Subject: Re: Inglenook P/58/19/PL

For clarification Wilbar Associates were asked to undertake an independent review of the planning application in regard to highway and transport. it was not asked to put forward any options to assist in making the application acceptable.

Visibility Splays and Internal Swept Path Analysis

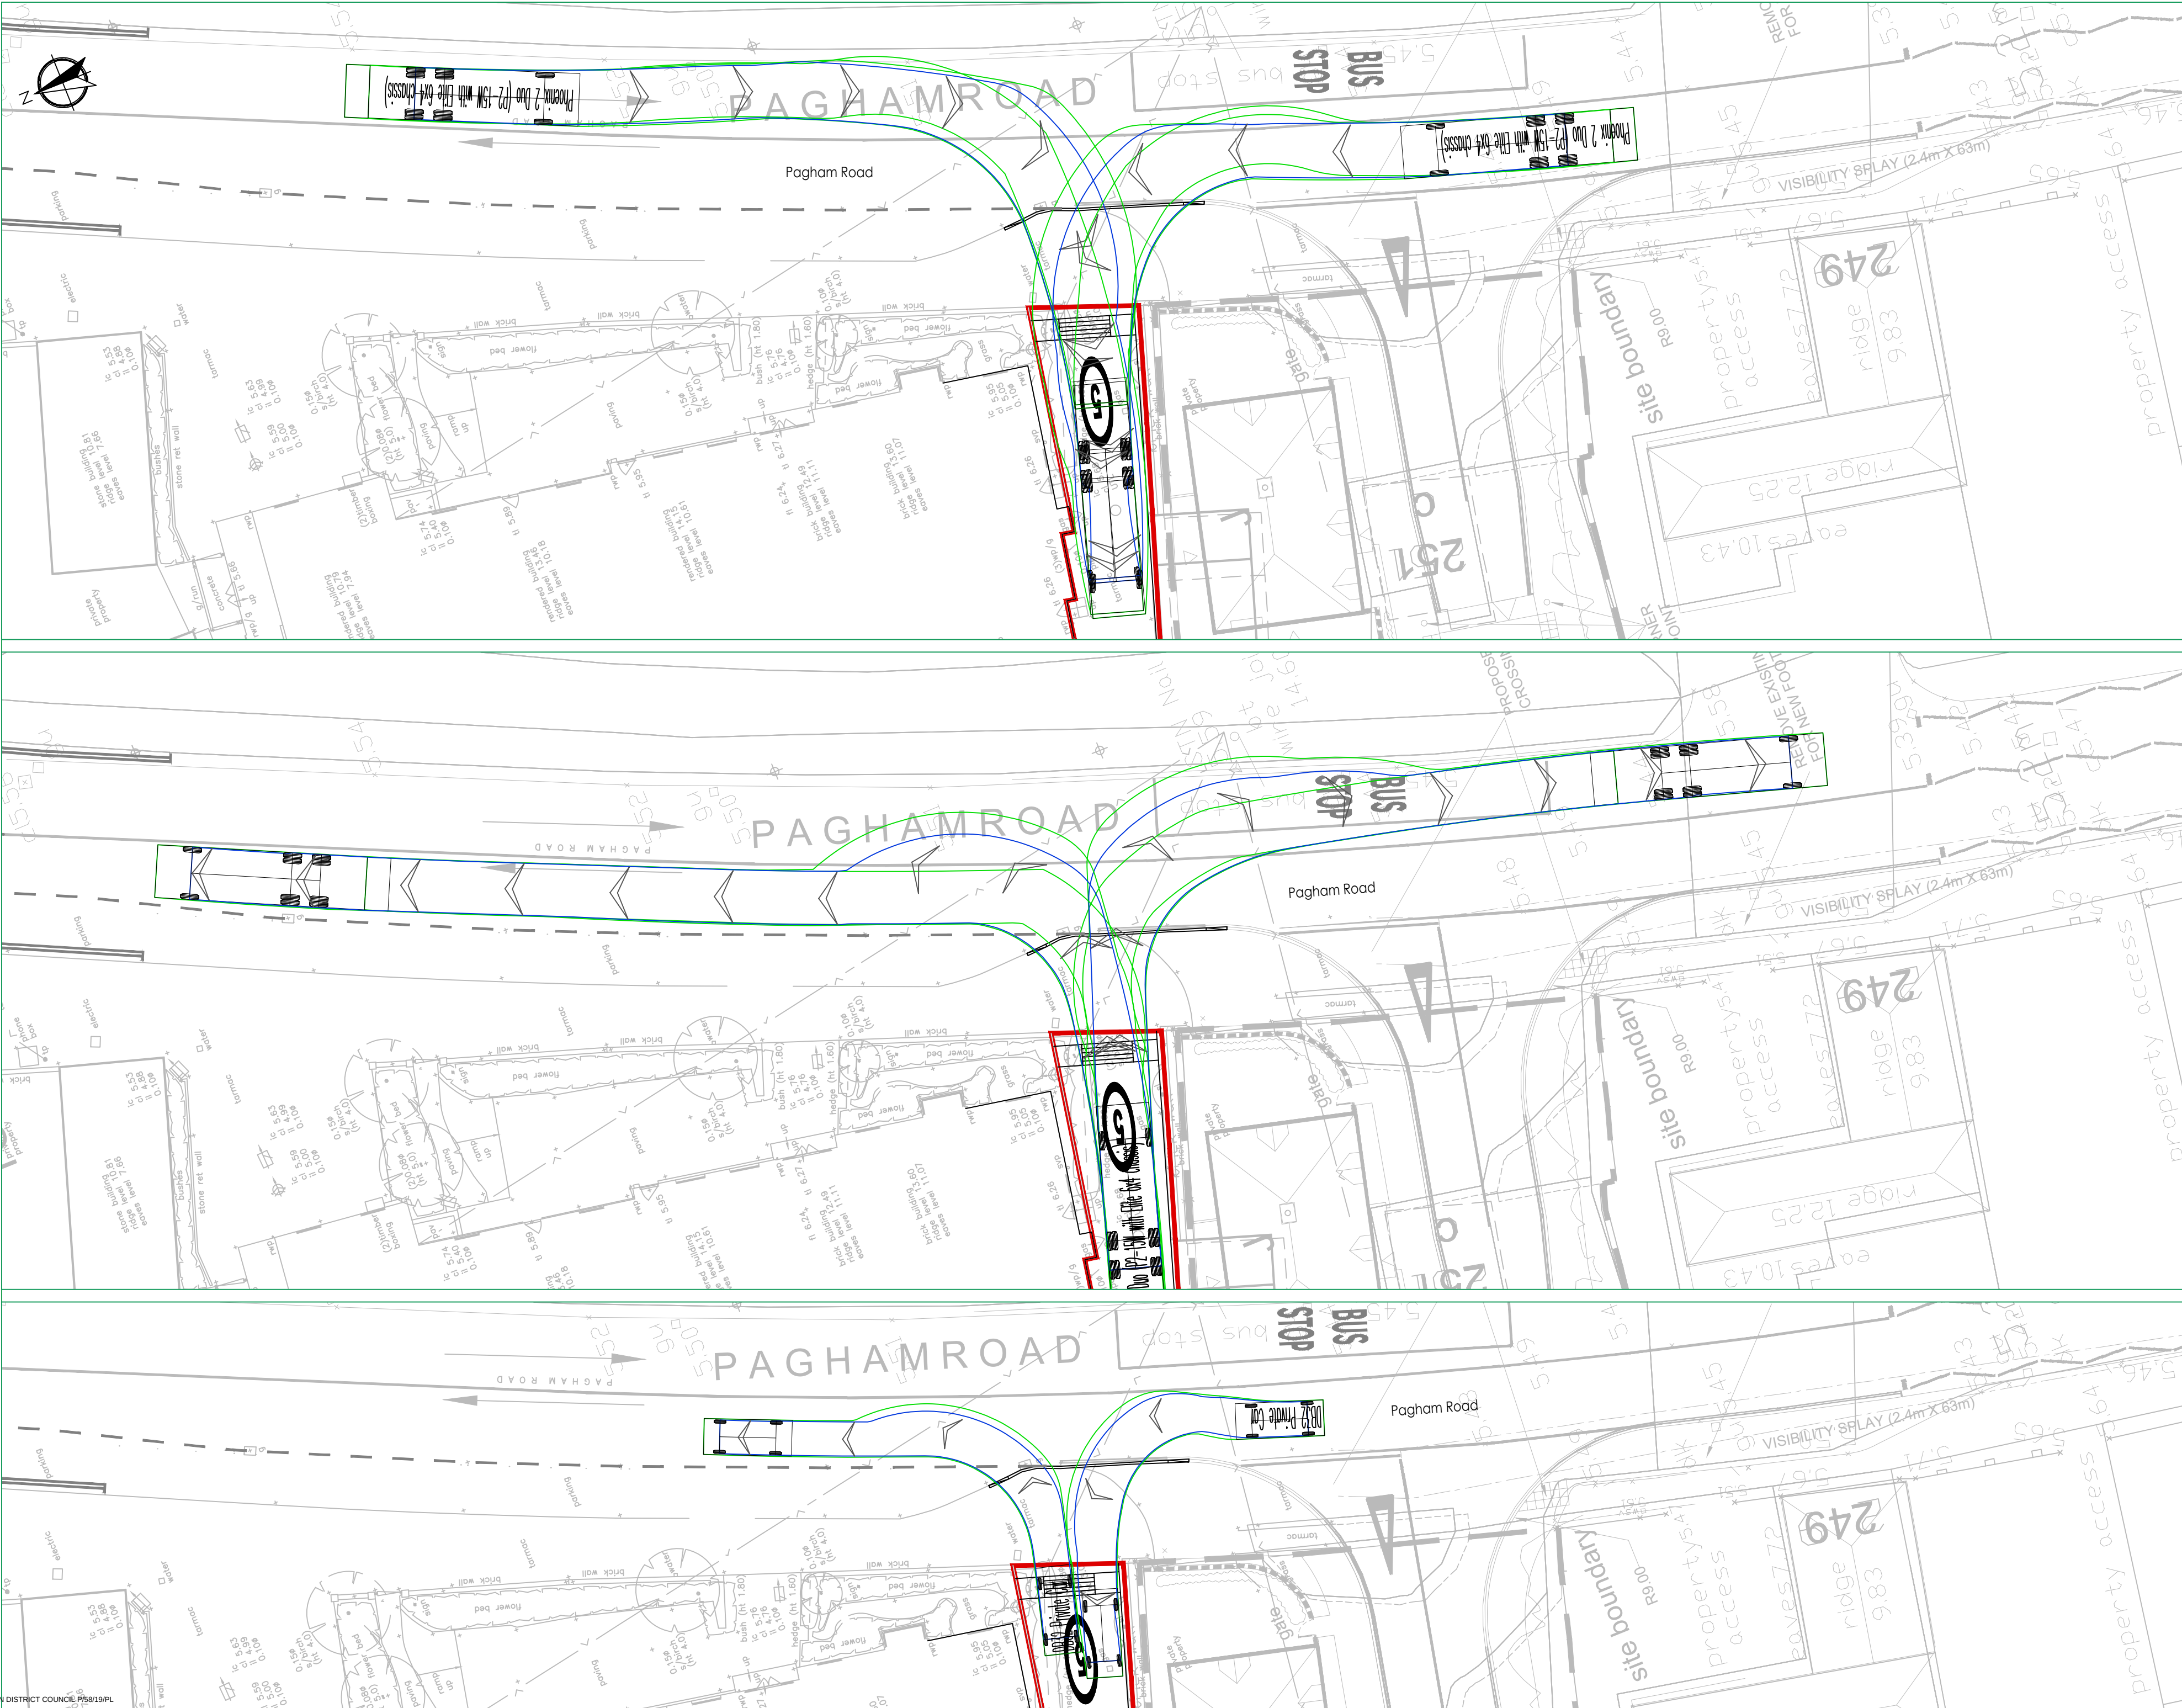
We also discussed the visibility issue on Pagham Road and the issue with the layby blocking the view with oncoming traffic. The layby is directly to the left of the access and if a high sided vehicle was to park there would be zero visibility. If the layby can't be reduced and oncoming drivers are over the centre line then there would be a higher risk of collision. Parking restrictions opposite would slightly reduce the risk and would also aid refuse and delivery vehicles entering the site but the layby is still of high concern. The inter-visibility between pedestrians and drivers was set out in Section 5.1.4. of the report, if this can't be achieved this is an additional hazard. A typical access road is shown in the photo below that gives better visibility and awareness through kerbing and tactile paving.
